DISAPPROVED
 Plan Review
 03/20/2019 3:33:00 PM
 dsdrangel
 EPC Planning & Community
 Development Department

PLOT PLAN

LEGAL DESCRIPTION
 LOT 29 ✓
 THE GLEN AT WIDEFIELD SUBDIVISION FILING NO. 8
 EL PASO COUNTY, COLORADO

ADDRESS
 7311 BIGTOOTH MAPLE DRIVE ✓

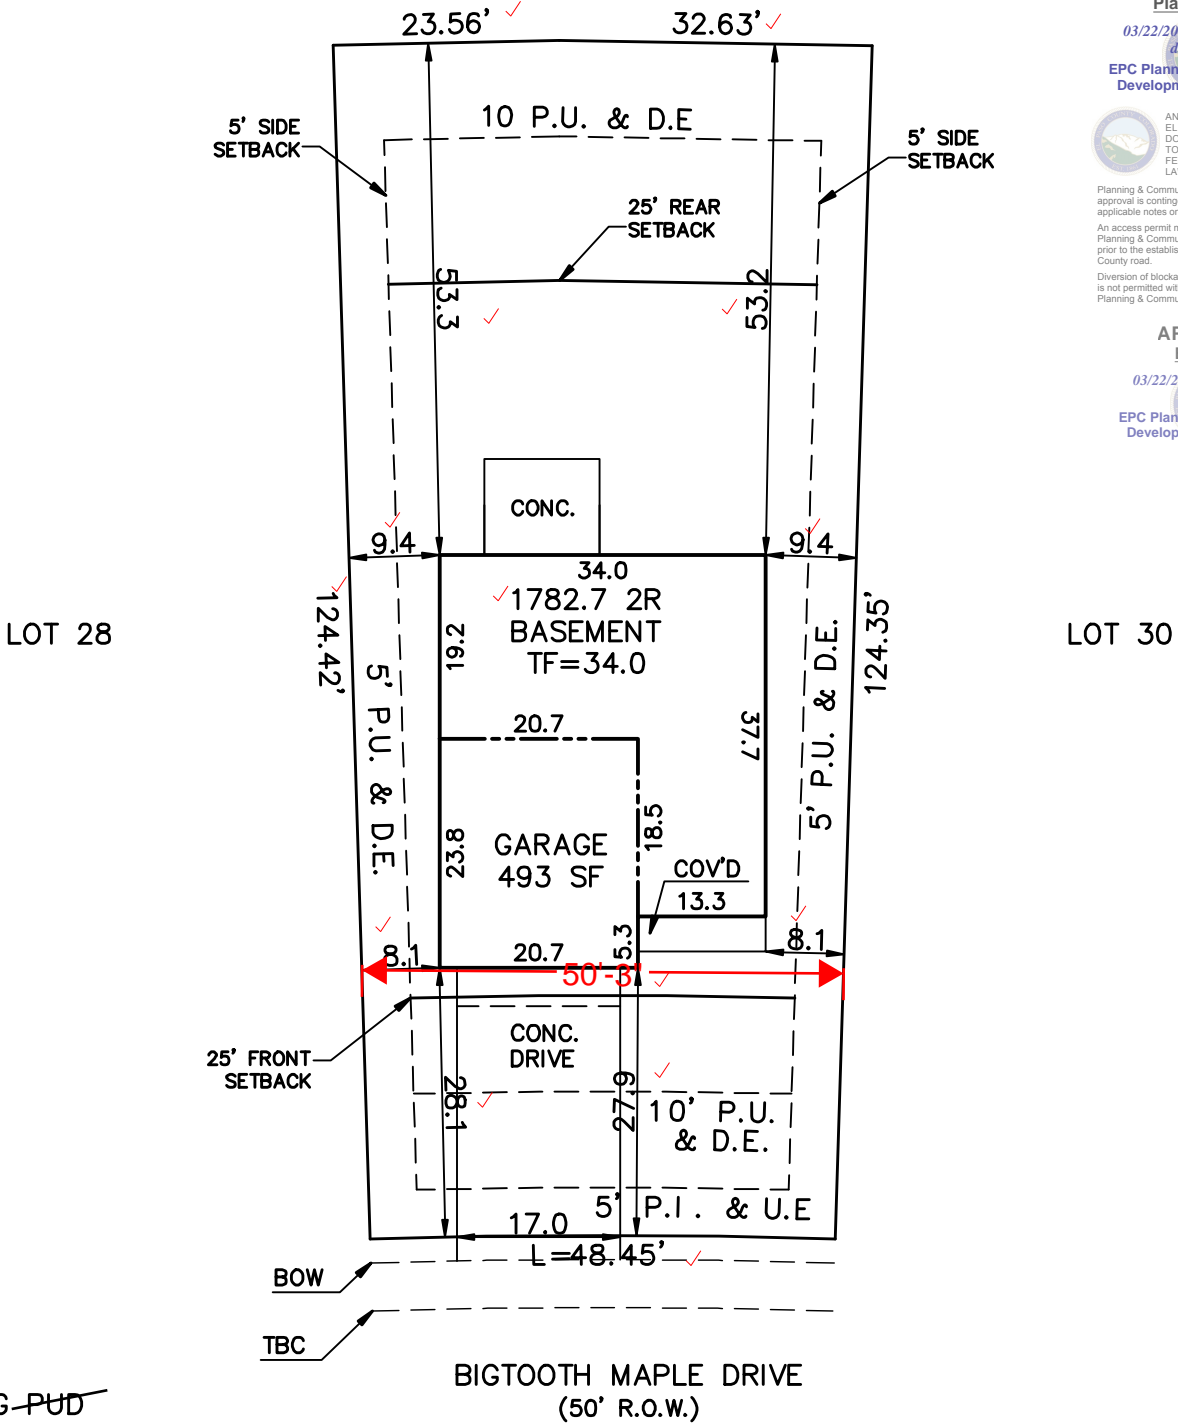
Front width at
 setback line is 48'
 6" where 50' is
 required
